STAFF REPORT

Northwest Chimpanzee Sanctuary Conditional Use Permit (CU-15-00007)

TO: Kittitas County Hearing Examiner
FROM: Kittitas County Community Development Services Staff
RE: Northwest Chimpanzee Sanctuary Conditional Use Permit (CU-15-00007)
DATE: September 8th (Hearing Date)

SITE PLAN
SCALE 1" = 60'

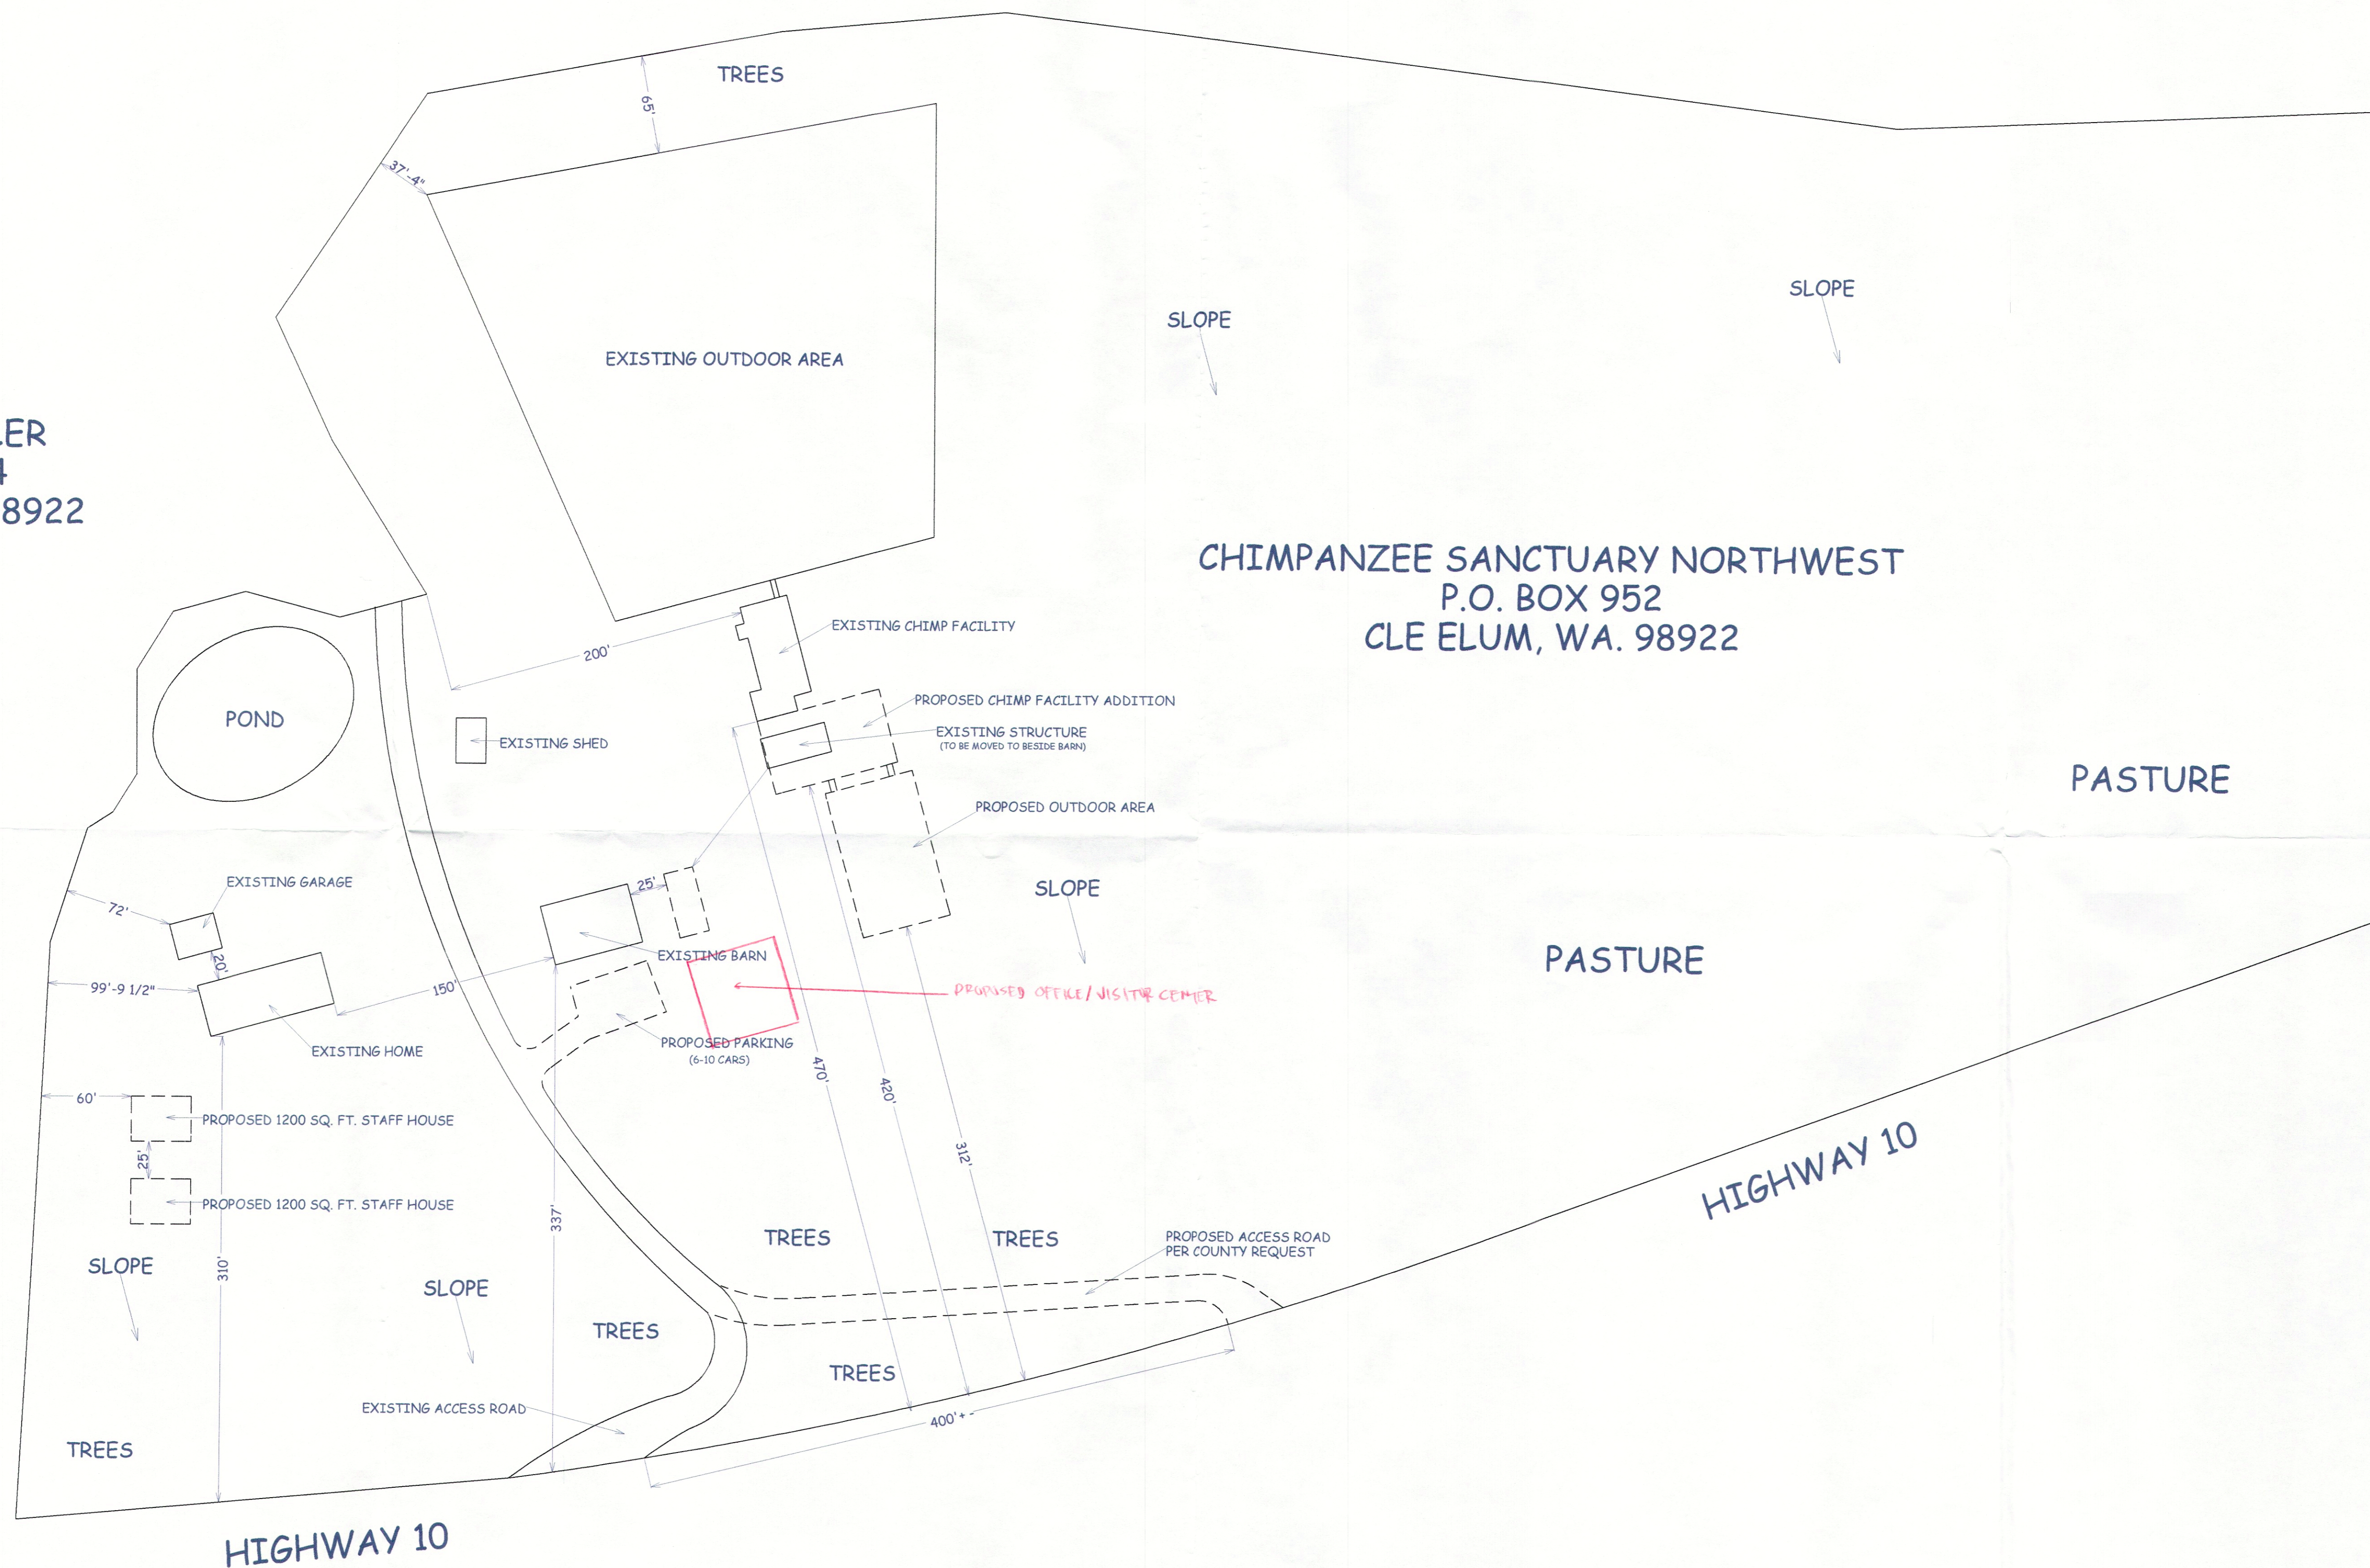
- B) On the revised access plan, the shared BPA/NWCS access may cross 40 foot wetland buffers. Ecology recommends wetland reconnaissance and possibly wetland reporting and mitigation. Ecology also requires an NPDES Stormwater Construction General Permit (Exhibit Index # 26, 43, 44).

5. The access must be moved south so that required sight distance of 495 feet is met. In meeting this requirement, the applicant has agreed to build a shared access with Bonneville Power Administration.

proposed new road approach may intersect potential wetland areas. A wetland delineation and mitigation report will be required and reviewed by the Department of Ecology. Ecology offers assistance in wetland reconnaissance to determine whether such reports are required (Exhibit Index # 32).

6. A new Access Connection Permit must be obtained. The property owner must contact the WSDOT South Regional Office to apply for the permit. Plans have been revised depicting the new access (Exhibit Index #15. 23, 41,42).
